Morris Goding
Access Consulting

Doran Drive Precinct, Doran
Drive, Castle Hill NSW

**DA Access Review
Final**

22 April 2022

ADAPTABLE HOUSING DESIGN COMPLYING APARTMENTS

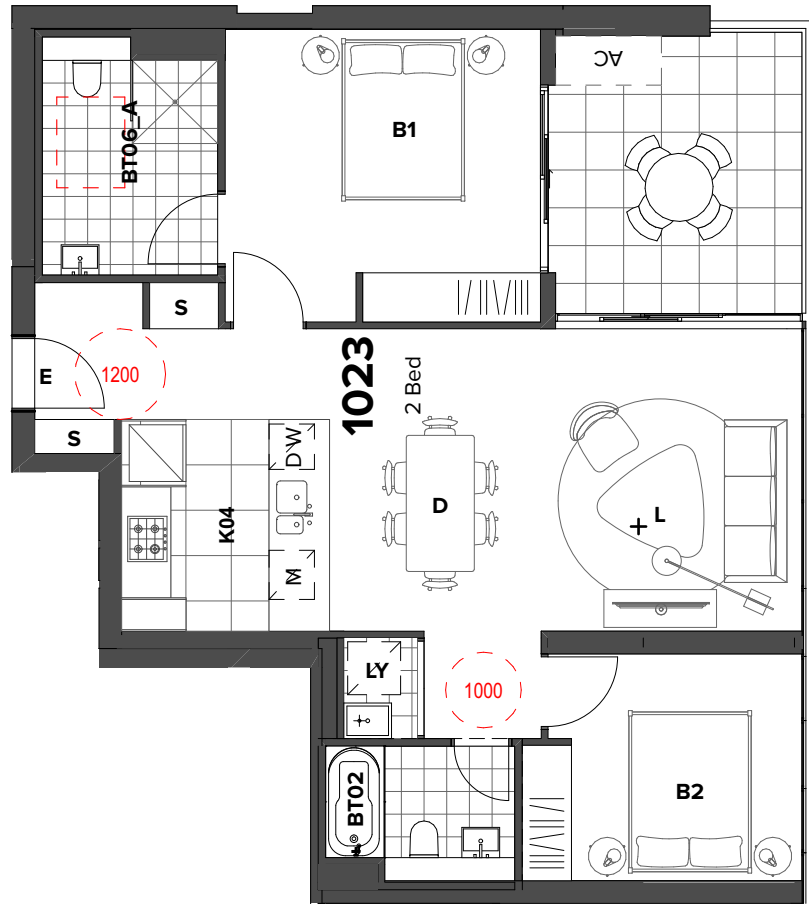
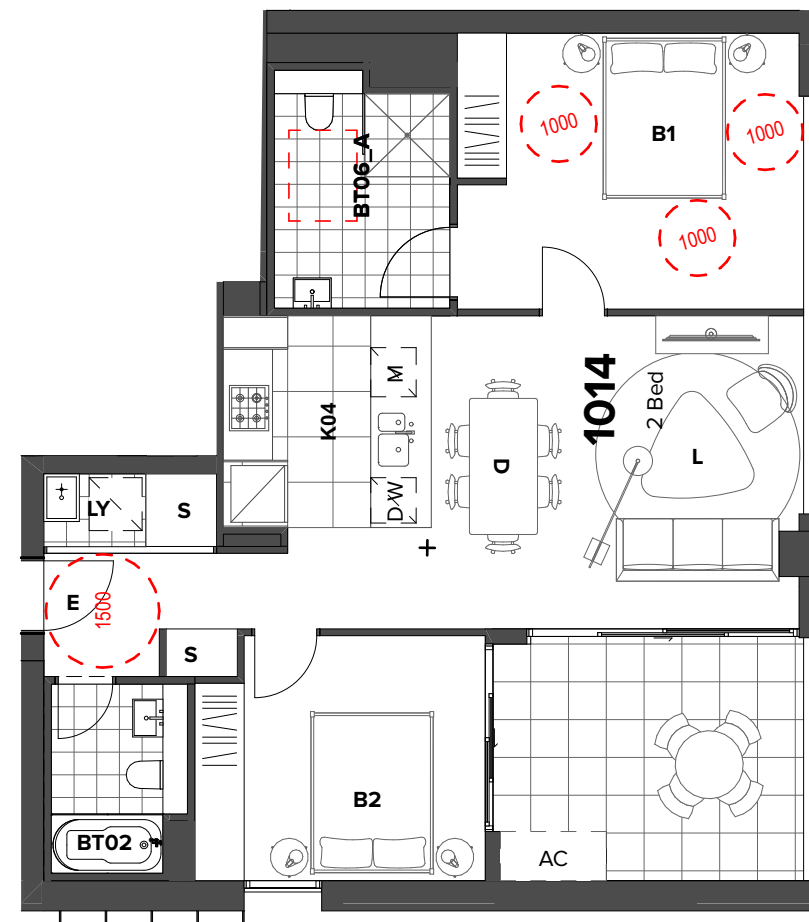
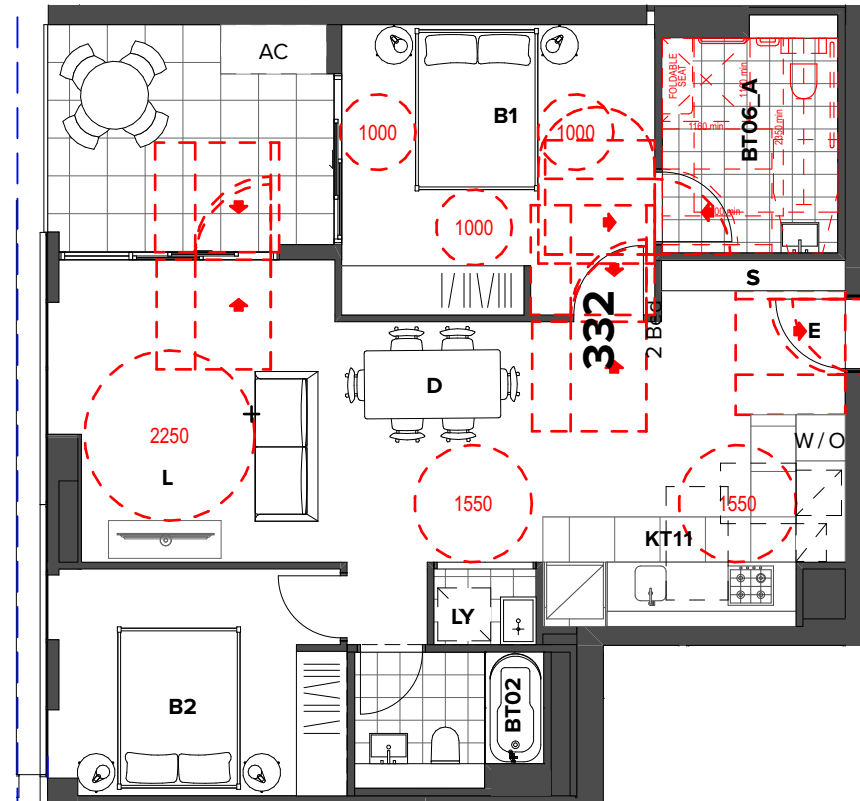
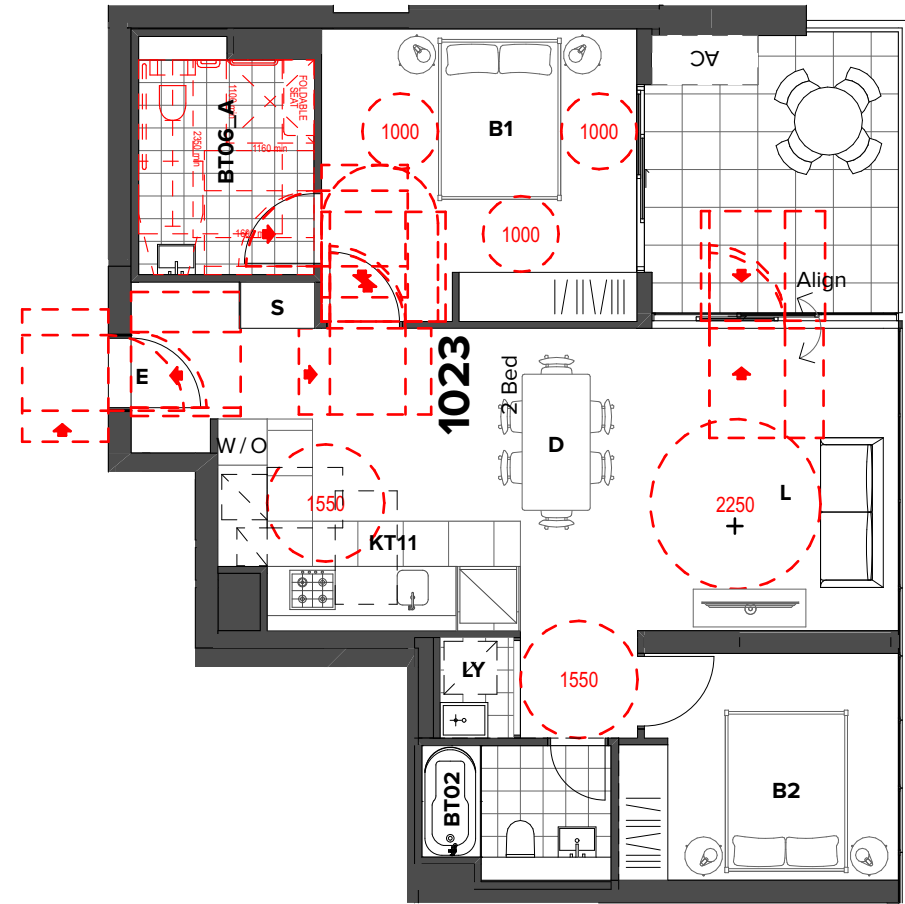
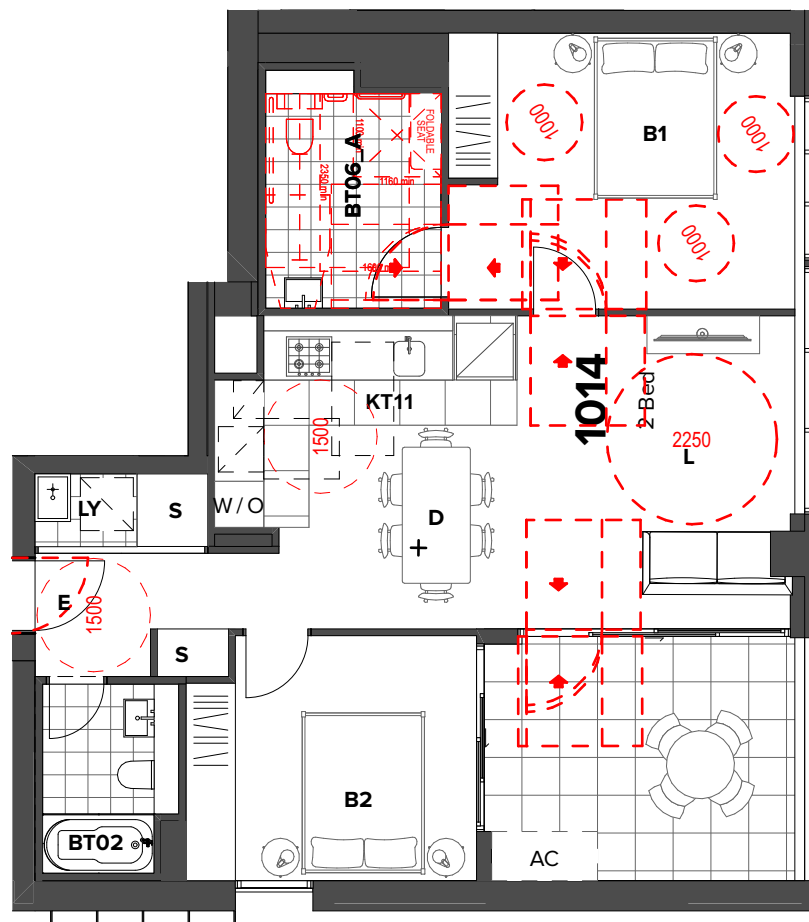
- A total of 43 adaptable units are required based on Council DCP 2012 B Section 5 Residential Flat. Currently this requirement is not achieved as only 42 adaptables are being provided.
- The adaptable units are to be designed in accordance with AS4299 Class C.
 - (c) At least 1, or 5 percent, of the units in a development of 20 or more dwellings must be either;
 - an accessible unit to Australian Standard 1428 Part 2, suitable for occupation by a wheelchair user; or
 - meeting Class B adaptability under Australian Standard 4299.

- The bedroom achieves 1 metre either side of queen size bed and 1550 x 2070mm at the base of the bed or similar configuration. Currently, this requirement is not achieved as unit 2B_20 lacks 1-metre at the bedside clear circulation at the pre-and-post adaptable layout. There is also the lack of 1550mm x 2070mm clear circulation, this is a non-compliance to be addressed to meet the relevant code.
